# CITY OF ALBUQUERQUE

**RE: Ceja Vista Unit 1**  
**Engineer's Certification Date: 03/18/21**  
**Engineer's Stamp Date: 10/04/19**  
**Hydrology File: P09D002F**  
**CPN # 614193 & 614195**

**Re: Ceja Vista Offsites Unit 1  
Engineers stamp date 10-04-19 (P09 / D002F)  
Request for ROFG/SIA**

In response to your January 25, 2021 comment letter,

TITLE: **Ceja Vista Off-Sites Unit 1  
Pond and Slope Grading Plan**

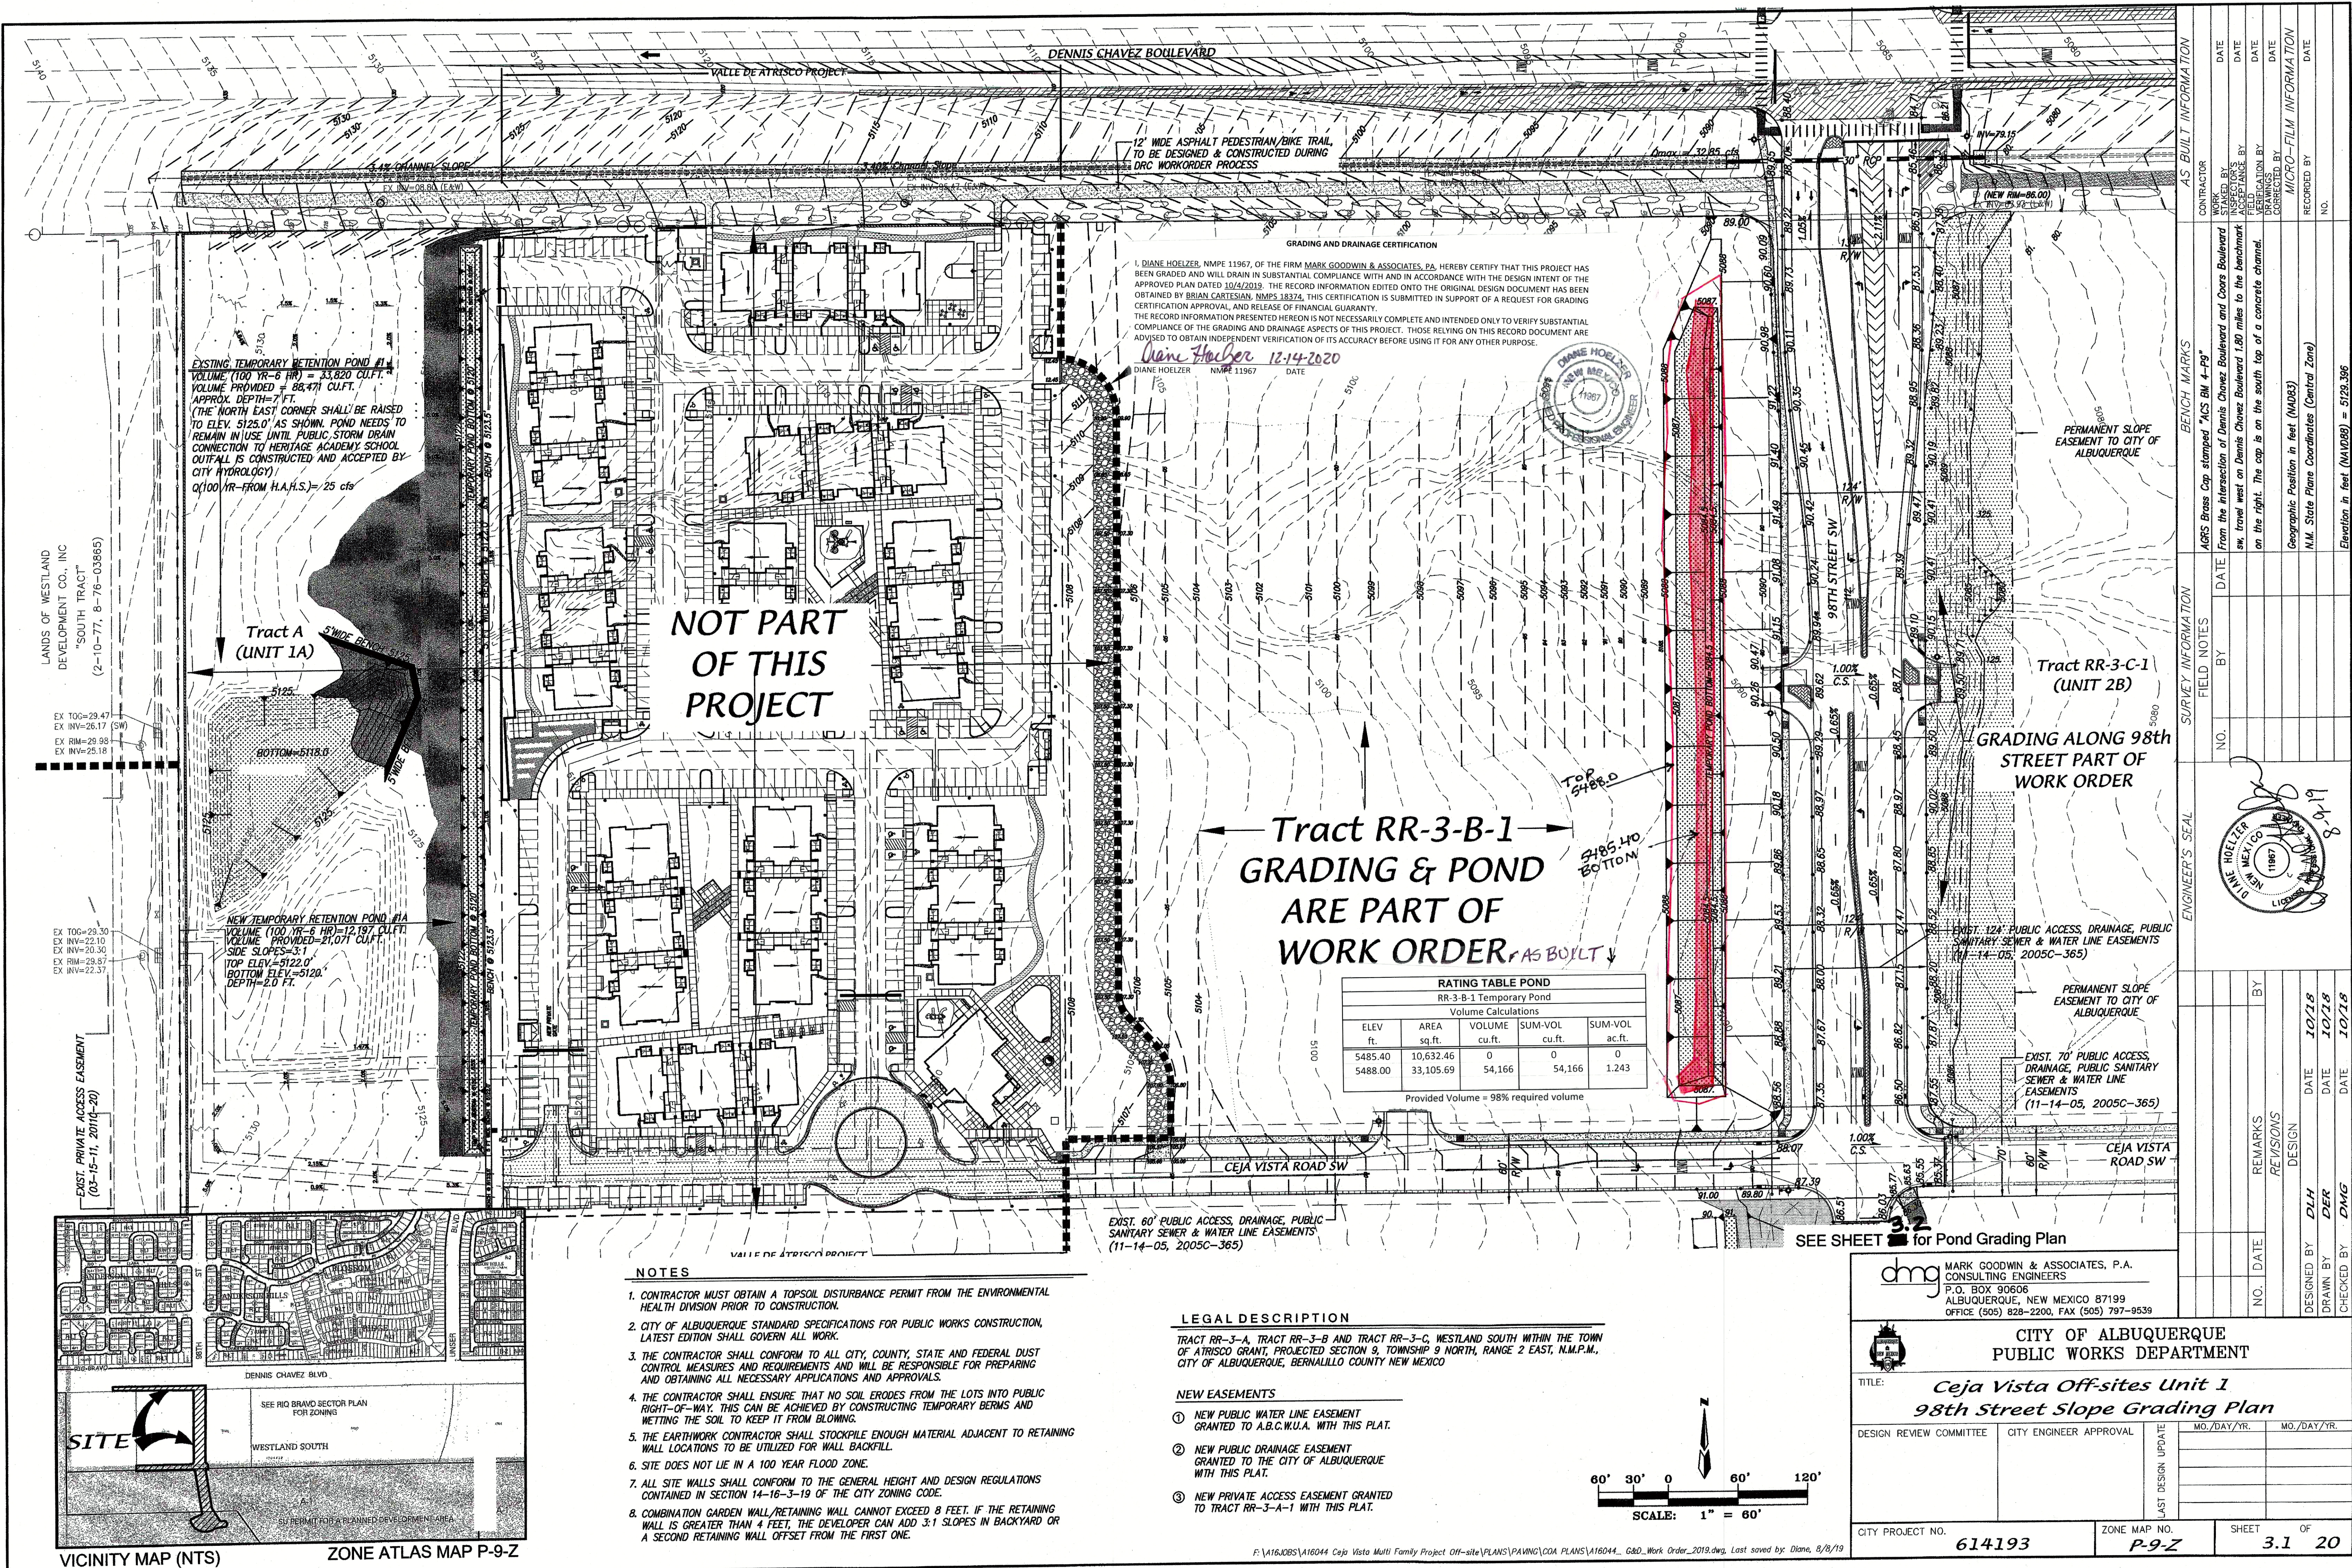
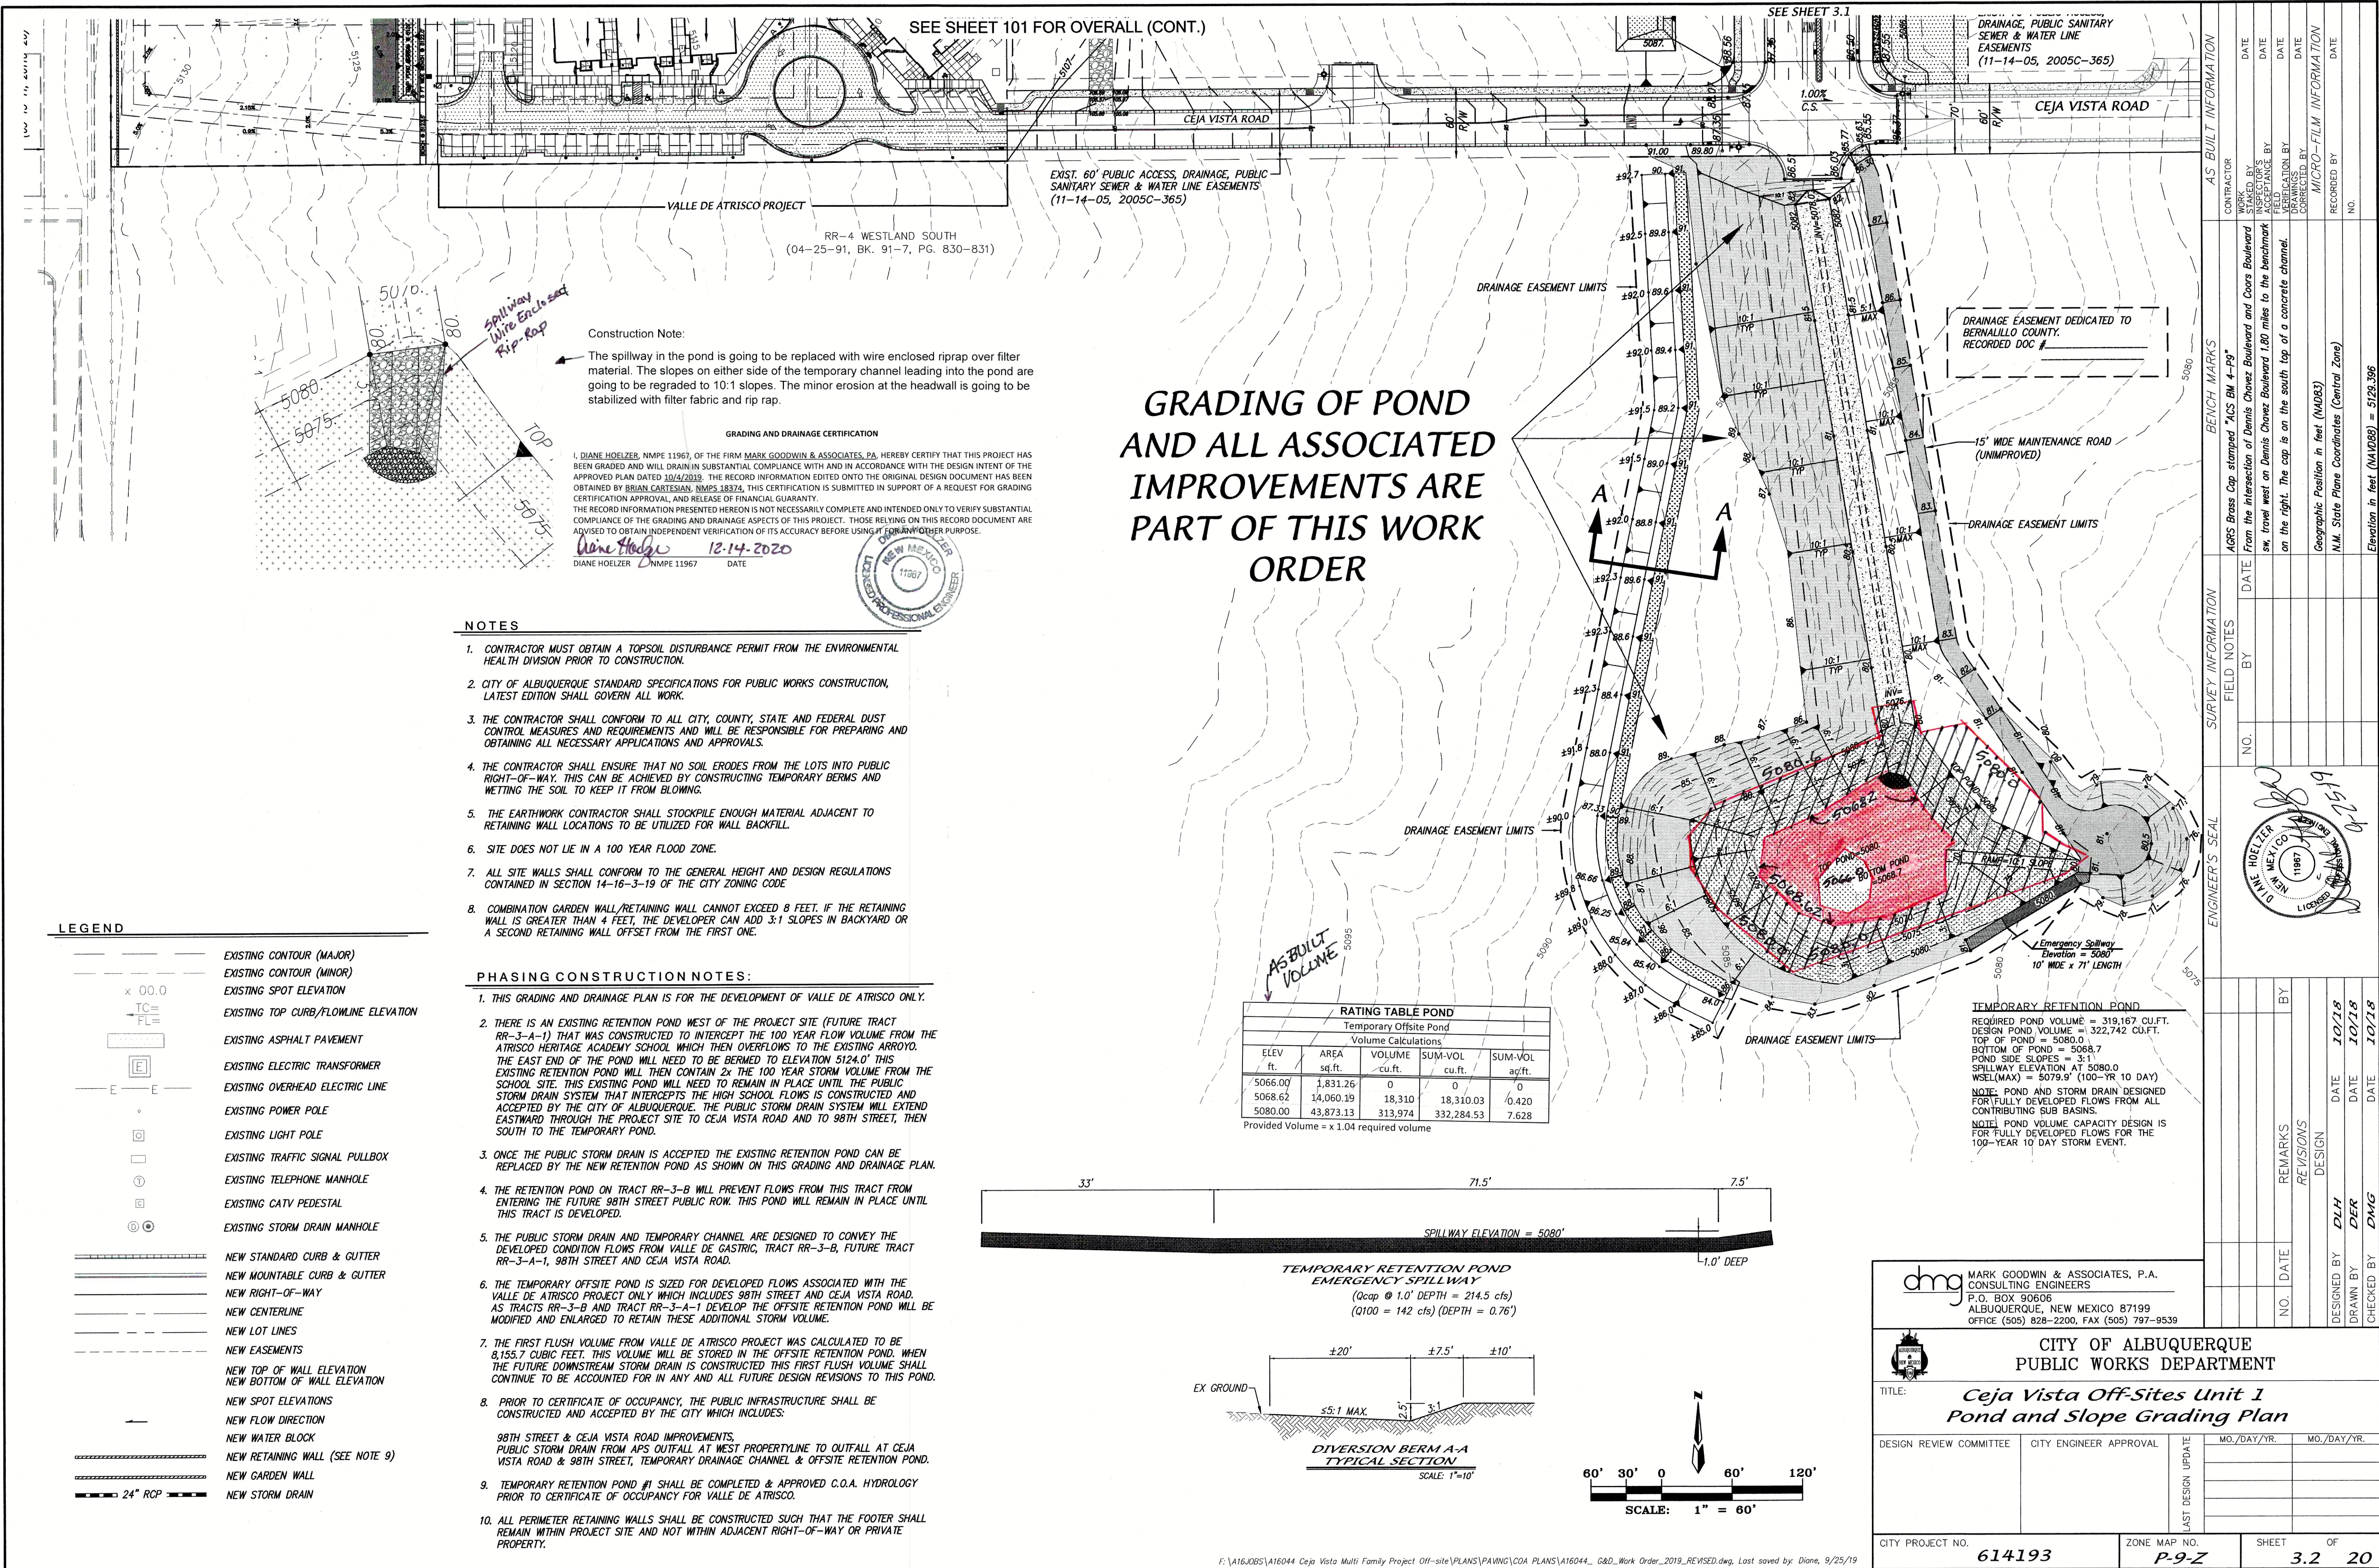
1. As built survey for the top and toe of the slope on the east side of 98<sup>th</sup> Street has been added to the grading plan. The as built contours have been added into the plan and replotted.

2. Tumble weeds have been removed from the channel. I didn't see any silt fence in the channel.
3. Side slopes adjacent to the channel have been reduced to 10:1 maximum. Survey along the top and bottom of slope are shown on the plan. As built survey contours along the maintenance road have been added.

4. The pond volume has been verified as shown on the plan. There is an existing berm around the pond. Silt fencing has been added along the crest of the berm. There was a spillway constructed but blowing sand has diminished it. A copy of the raw as built contour survey is included with this resubmittal.

With this re-submittal is a copy of the raw as built survey and a copy of the survey with contour line elevations show which are included as an attachment to the original 10-4-19 approved plans. The pond volumes were recalculated and are shown on this resubmittal. The spillway into the pond was replaced with wire enclosed rip rap over filter material as called out on sheet 3.3.
